WILLOWTREE PLANNING

REF: WTJ21 - 285

RE: RESPONSE TO SUBMISSIONS - PROPOSED SECTION 4.55(1A) MODIFICATION APPLICATION - SSD 9522 (MOD 2)

PROPERTY AT 657-769 MAMRE ROAD, KEMPS CREEK LOT 34 DP1118173, LOTS X & Y DP421633, LOT 1 DP 1018318 & LOT 22 DP258414)

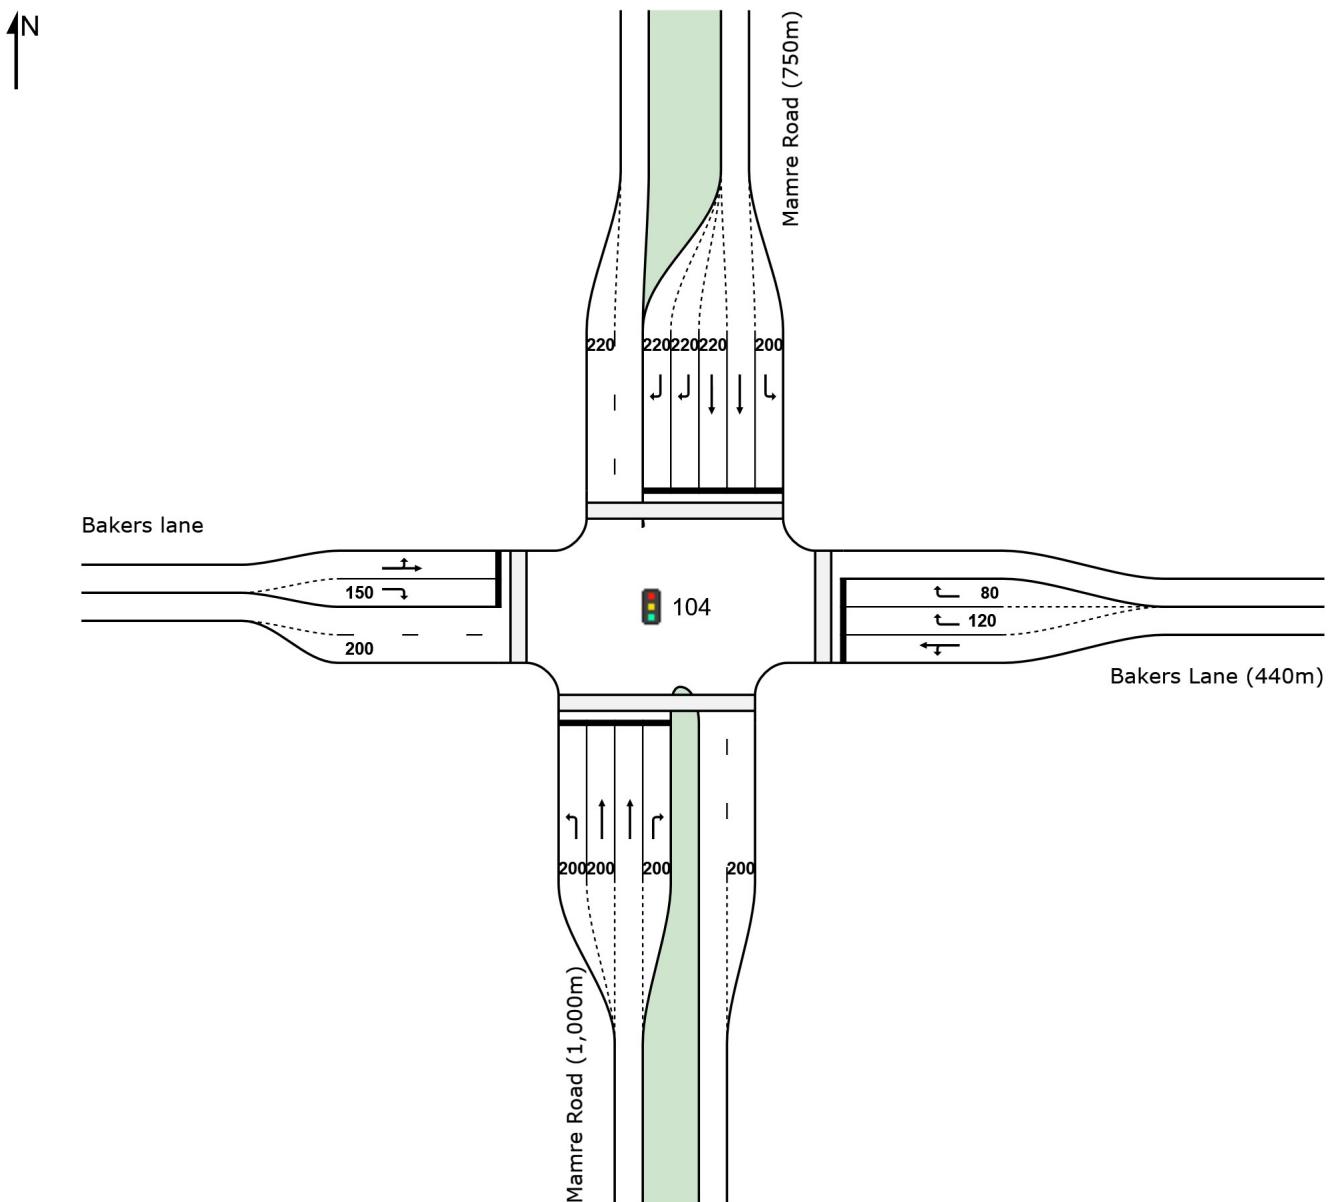
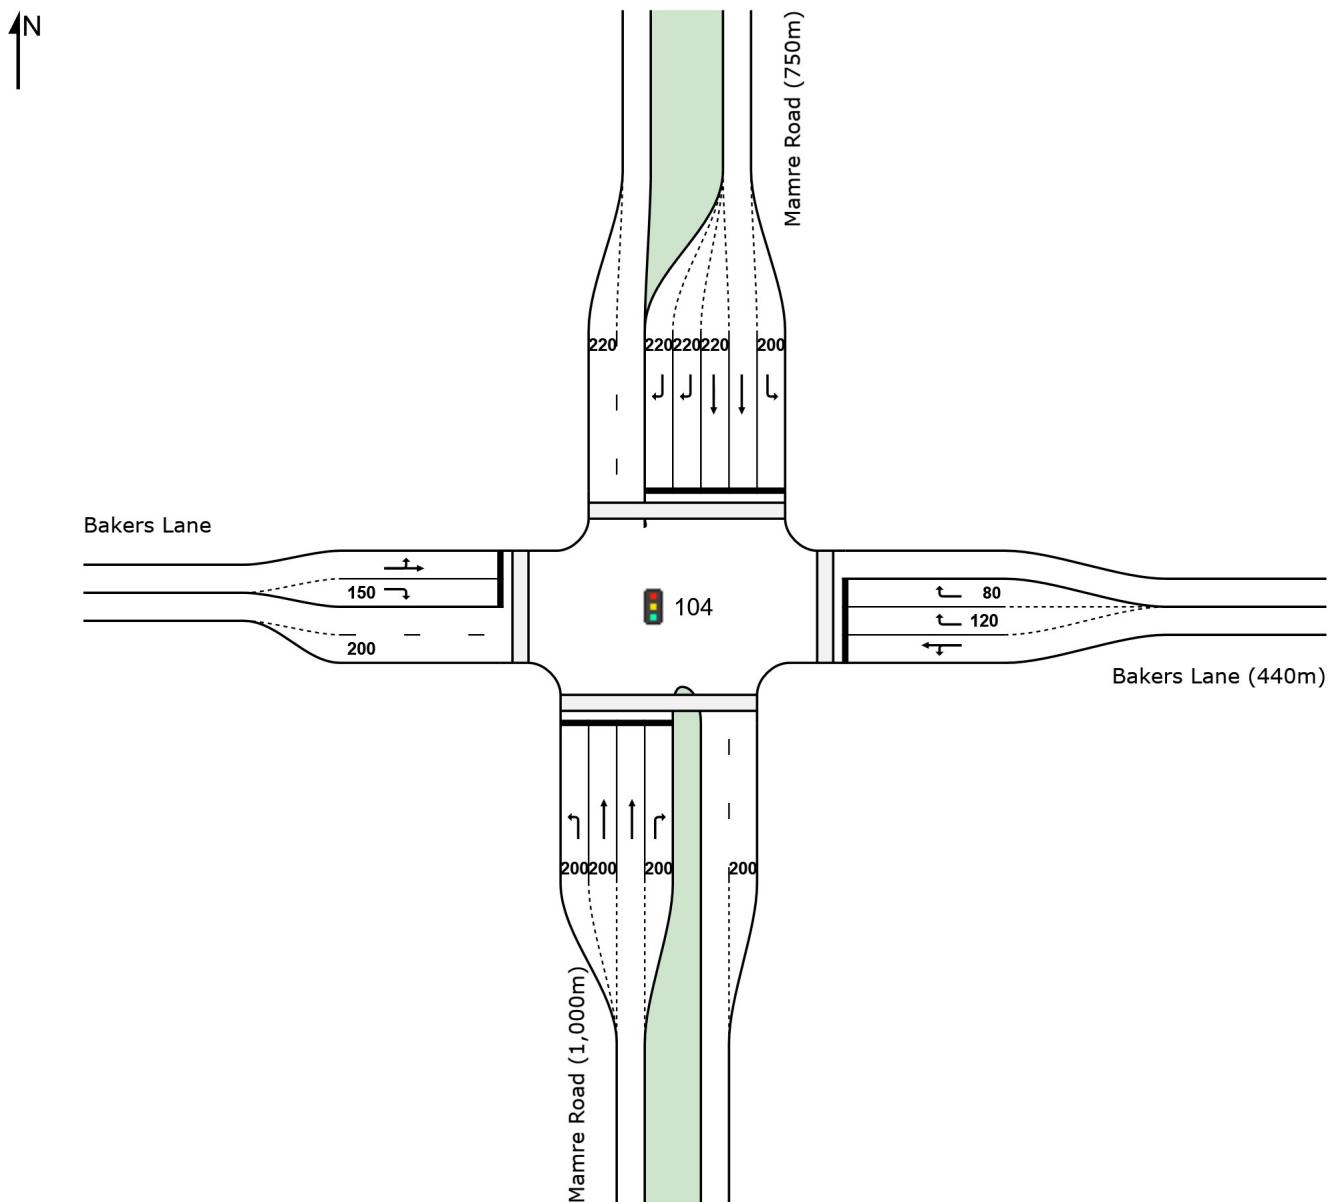
<p>It is recommended that all SIDRA movement summaries for Sequence 1B (and 1A Modified) are provided for review and comparison. All movement summaries should be provided for any updated modelling.</p>	<p>The following revised SIDRA modelling results (for the Mamre Road / Bakers Lane intersection in isolation) have been attached to Appendix 2:</p> <ul style="list-style-type: none"> Attachment A: Approved SIDRA modelling results for Sequence 1B and Modified Sequence 1A with 80 second cycletime (2025) with and without development traffic; Attachment B: SIDRA modelling results for Sequence 1B and Modified Sequence 1A with 80 second cycletime (2026) with and without development traffic; Attachment C: SIDRA modelling results for Modified Sequence 1A with 120 second cycletime (2026) with and without development traffic; Attachment D: SIDRA movement summary for approved sequence 1B (2025) with and without development traffic; Attachment E: SIDRA movement summary of amended Modified Sequence 1A (two lane approach at Distribution Drive) with and without development traffic; and Attachment F: SIDRA movement summaries of Sequence 1B and Modified Sequence 1A with 80 second cycletime (2026) and Modified Sequence 1A with 120 second cycletime (2026) with and without development traffic

Summary of, and response to comments	
Comments	Response
	Revised electronic SIDRA files will be emailed to TfNSW to review, along with this memo.
Central Western Team Comments	
Road widths and design proposed by SSD-9522 Mod 2 must comply with the Mamre Road Precinct Development Control Plan 2021.	The road widths as proposed maintain compliance with the Mamre Road Precinct DCP
The proposed revised road widths should ensure that the buildings within the development comply with the landscaped setbacks established within the Mamre Road Precinct DCP 2021.	The development as modified will continue to provide areas for landscaping which are generally consistent with the approved development and site-specific DCP. Where appropriate, landscaped setbacks in excess of the requirements have been provided to compensate for any minor carpark intrusion into the landscape setbacks required by road curves. The overall quantum of landscaping is increased.

02 PROPOSED COLLECTOR ROAD - SECTION AA
SCALE - 1:200 @ A1

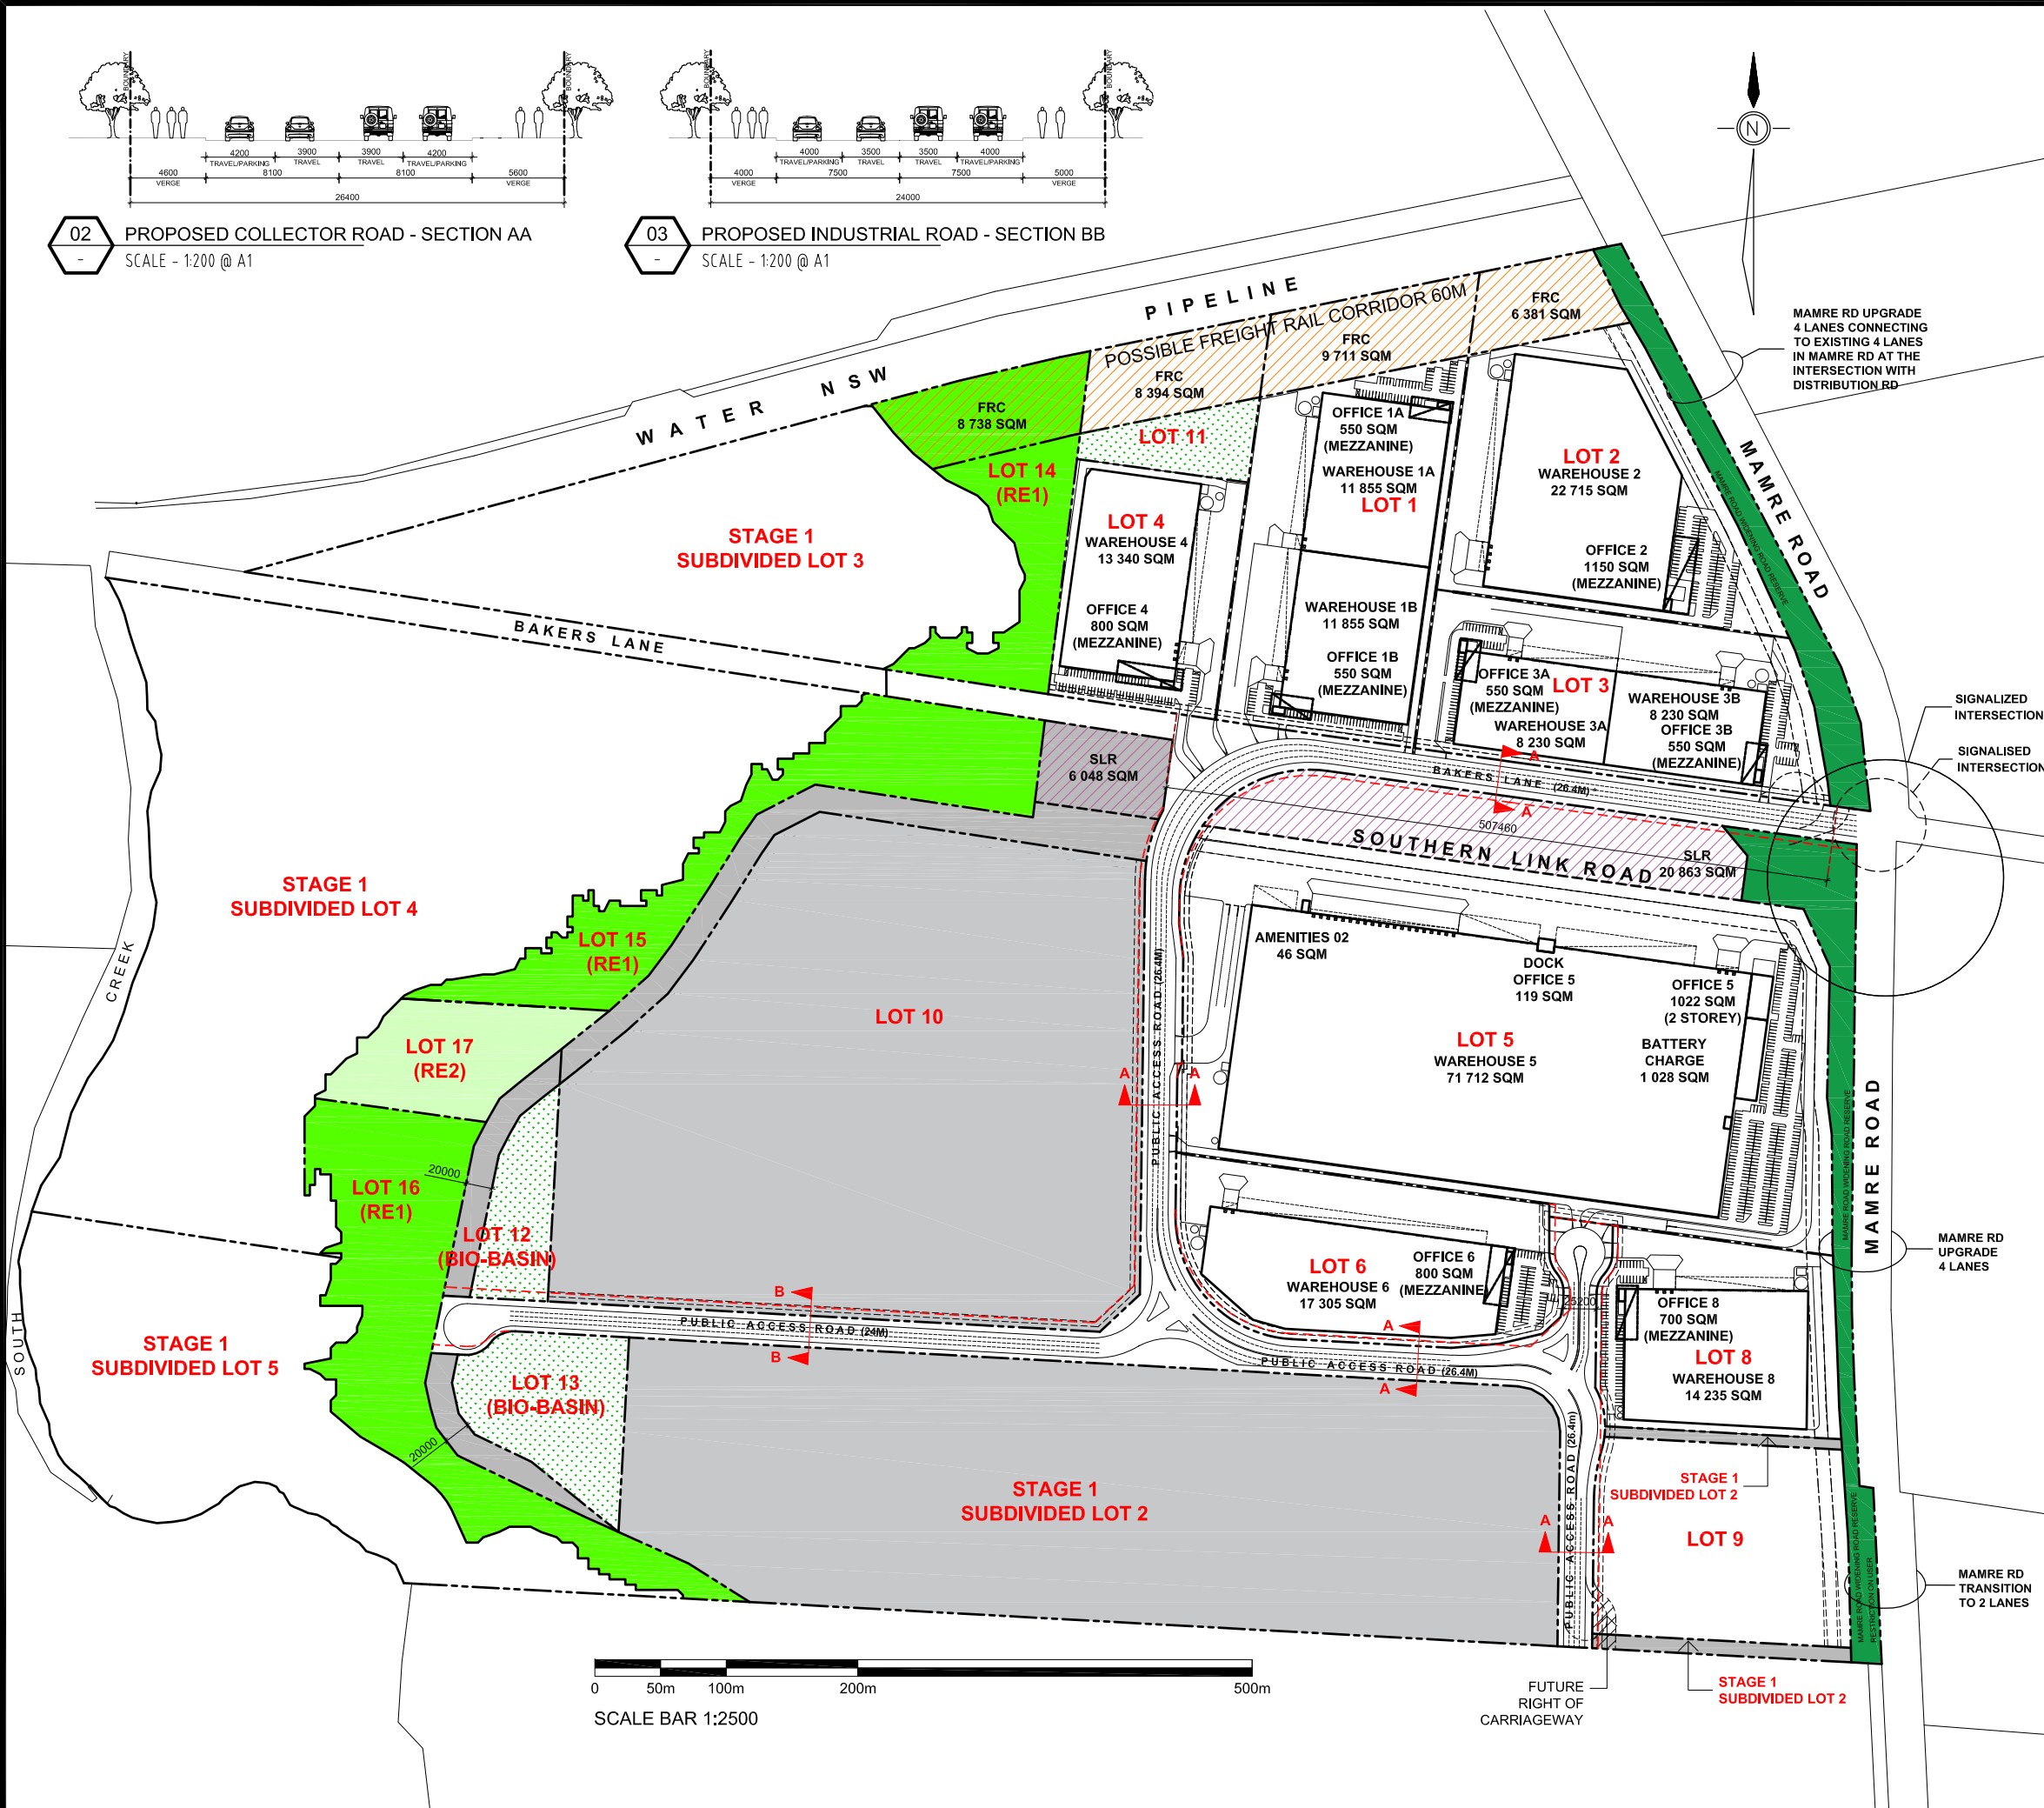
Summary of, and response to comments	
Comments	Response
<p>Council's requirements for wide landscaped medians were considered in the Department's assessment report attached to MOD 1 and the applicant amended the site plan to meet Council's minimum standards.</p> <p>No valid justification is provided for the deletion of the central landscaped medians, and it is noted that GFA is increased again under this Modification from 186,123sqm to 187,378sqm (a further increase of 1,255sqm on top of the 23,768sqm GFA increase approved under MOD 1 (total 25,023sqm)).</p> <p>It is raised for Department's strong consideration that there are significant negative cumulative impacts resulting from:</p> <ul style="list-style-type: none"> – The continued increase in Gross Floor Area, – the reduction in landscaping opportunities, – incorporation of battle axe warehouse lots and warehouse amalgamation, and, – increased car parking numbers, hardstands and hard surfaces, coupled with, decreased landscaped setbacks, and – the deletion of estate wide landscaped central medians, is significantly eroding the quality of the development's contribution to the design quality of the Precinct and the site's contribution to canopy tree cover targets. 	<p>No change to the approved stormwater infrastructure is proposed and as advised, in the Civil Engineering documentation submitted, the stormwater infrastructure is appropriately sized to accommodate the nominal increase in GFA.</p> <p>Noted.</p> <p>The proposed modifications are generally consistent with the cross sections nominated in the site-specific DCP and the Mamre Road Precinct DCP where road cross sections have been nominated.</p> <p>The proposed increase in GFA is nominal (0.7%) and will not result in any additional impacts to the precinct or surrounding land.</p> <p>The development as modified will continue to provide areas for landscaping which are generally consistent with the approved development and site-specific DCP.</p> <p>The general configuration remains unchanged under this modification application and as such this matter is not considered relevant.</p> <p>The development as modified will continue to provide areas for landscaping which are generally consistent with the approved development and site-specific DCP. Where appropriate, landscaped setbacks in excess of the requirements have been provided to compensate for any minor carpark intrusion into the landscape setbacks required by road curves. The overall quantum of landscaping is increased. The proposed modifications to the central medians are generally consistent with the site-specific DCP and the Mamre Road Precinct DCP where cross sections have been nominated.</p>
